**The Planning Act 2008 - Section 89 and The Infrastructure Planning (Examination Procedure)
Rules 2010 - Rule 8 (as amended)
Application by Highways England for an Order Granting Development Consent for the A303
Sparkford to Ilchester Dualling**

From: Carleton Earl.
Area Footpath Secretary, Somerset Ramblers
Fulwood House
Winsham
Chard TA20 4EE

**The Planning Act 2008 - Section 89 and The Infrastructure Planning (Examination Procedure) Rules 2010 - Rule 8 (as amended)
Application by Highways England for an Order Granting Development Consent for the A303 Sparkford to Ilchester Dualling**

INSET F: EXISTING ROADS AND PROW TO BE STOPPED UP

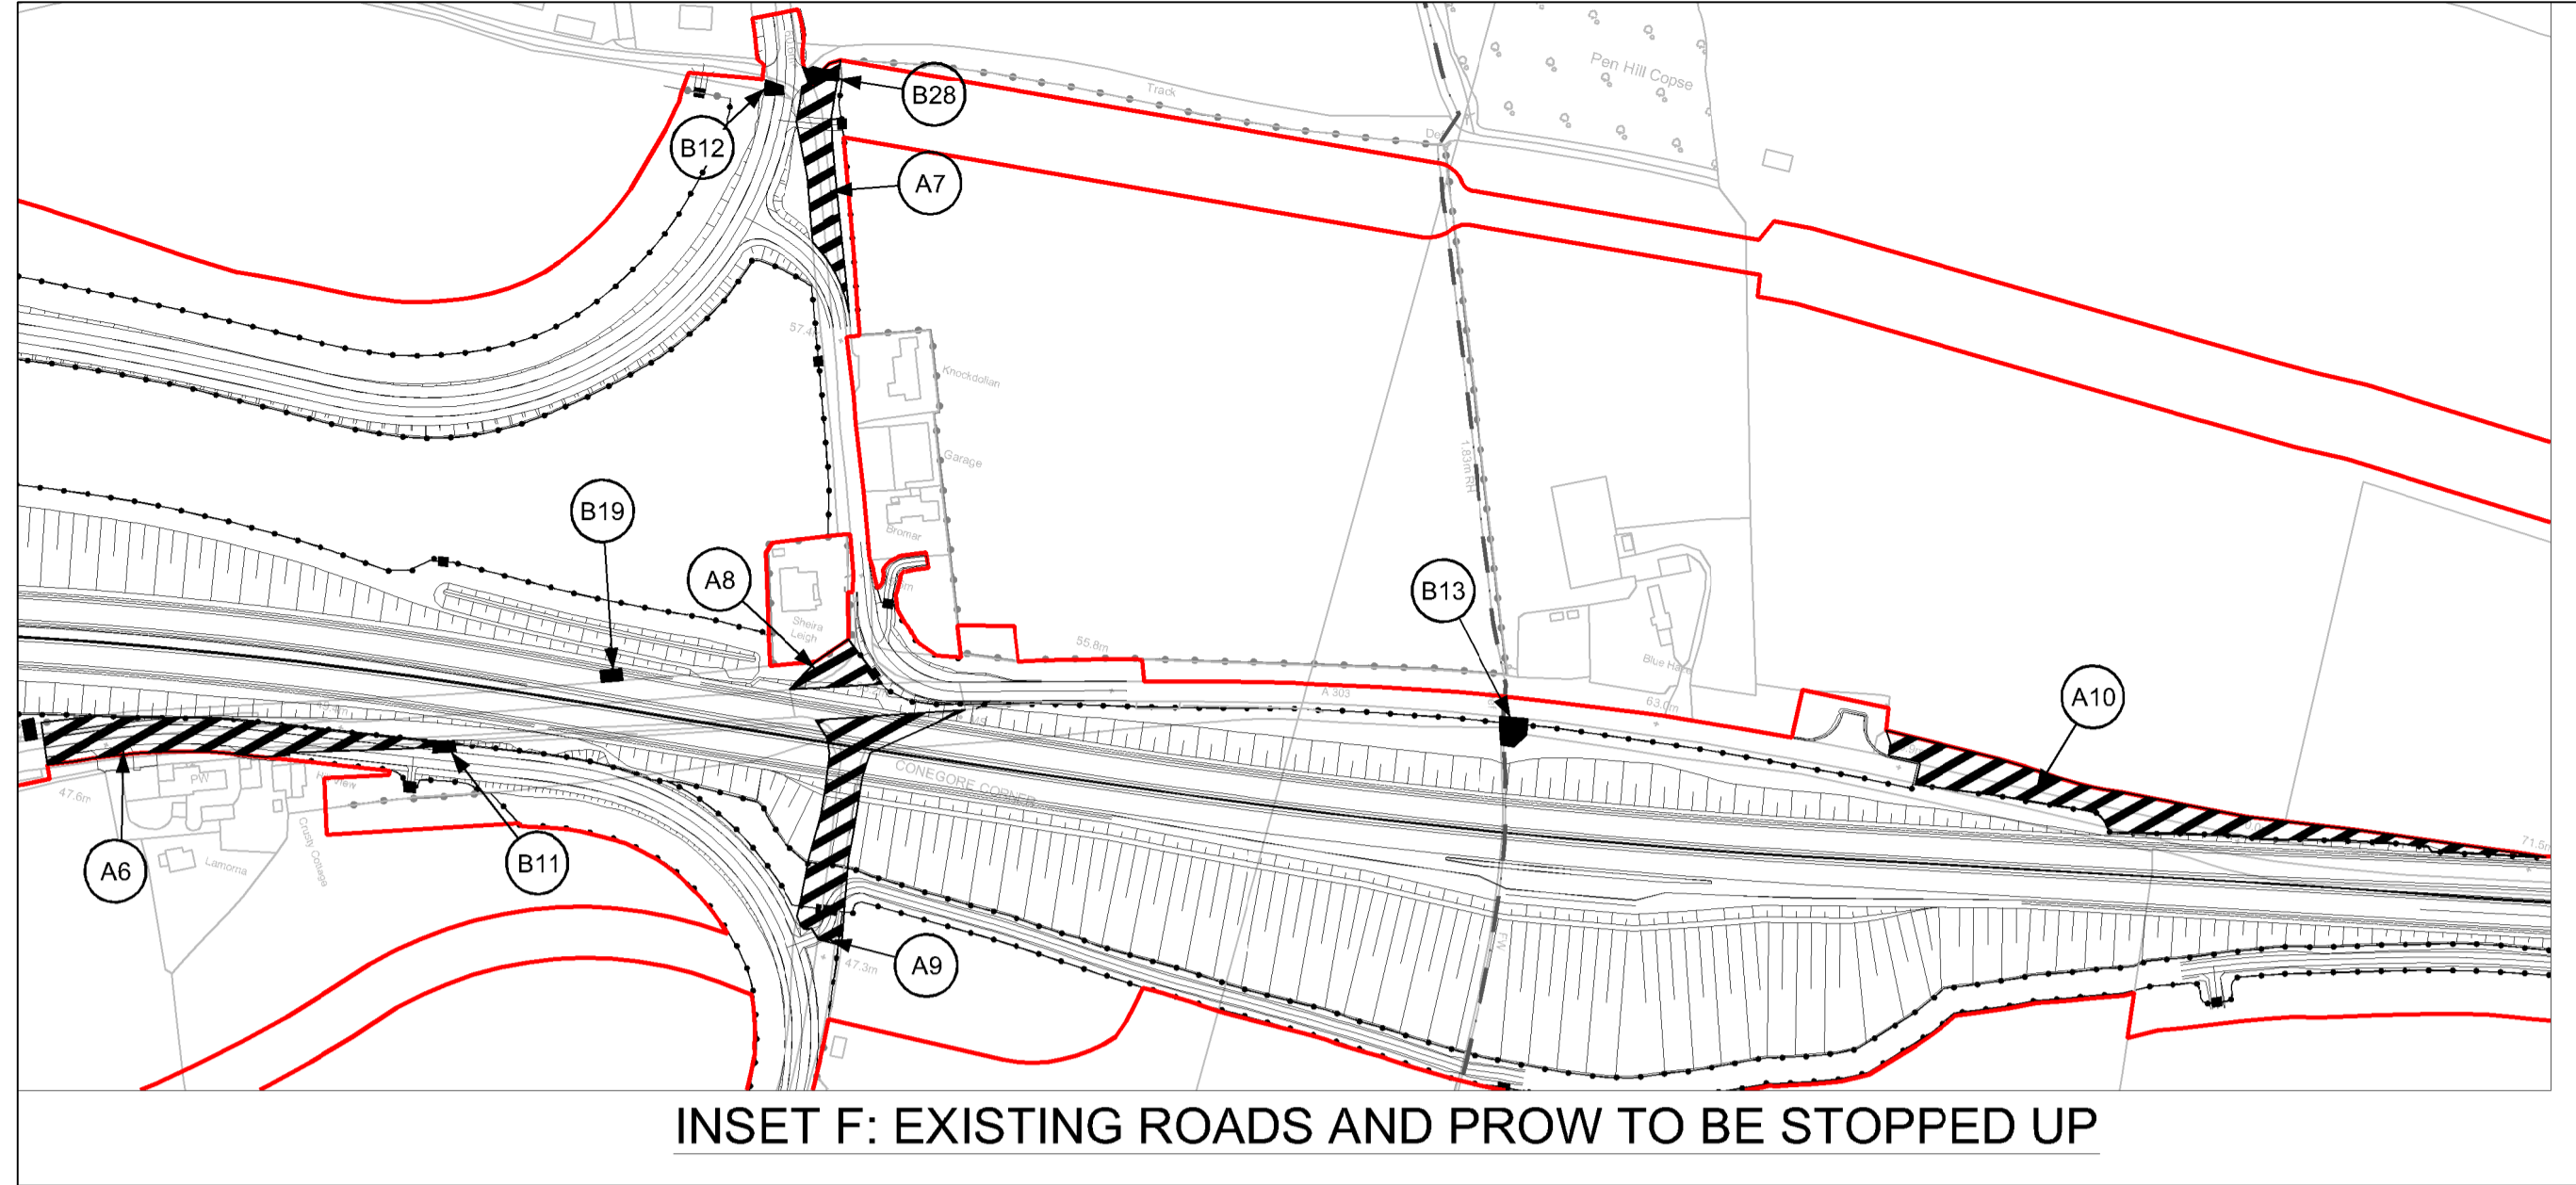
2. Part 1 of Schedule – Queen Camel – stopping up of Traits Lane and WN 23/32, 23/10 & 23/3.
Somerset Ramblers would ask that consideration be given to the provision of a pedestrian bridge in the general vicinity of Traits Lane where it meets the new road with appropriate connecting links to the above footpaths to provide safe connection between routes to the north and south of the new road. To require walkers to go east to cross at Hazelgrove roundabout means an extensive diversion and walking alongside and crossing what will remain well used roads.
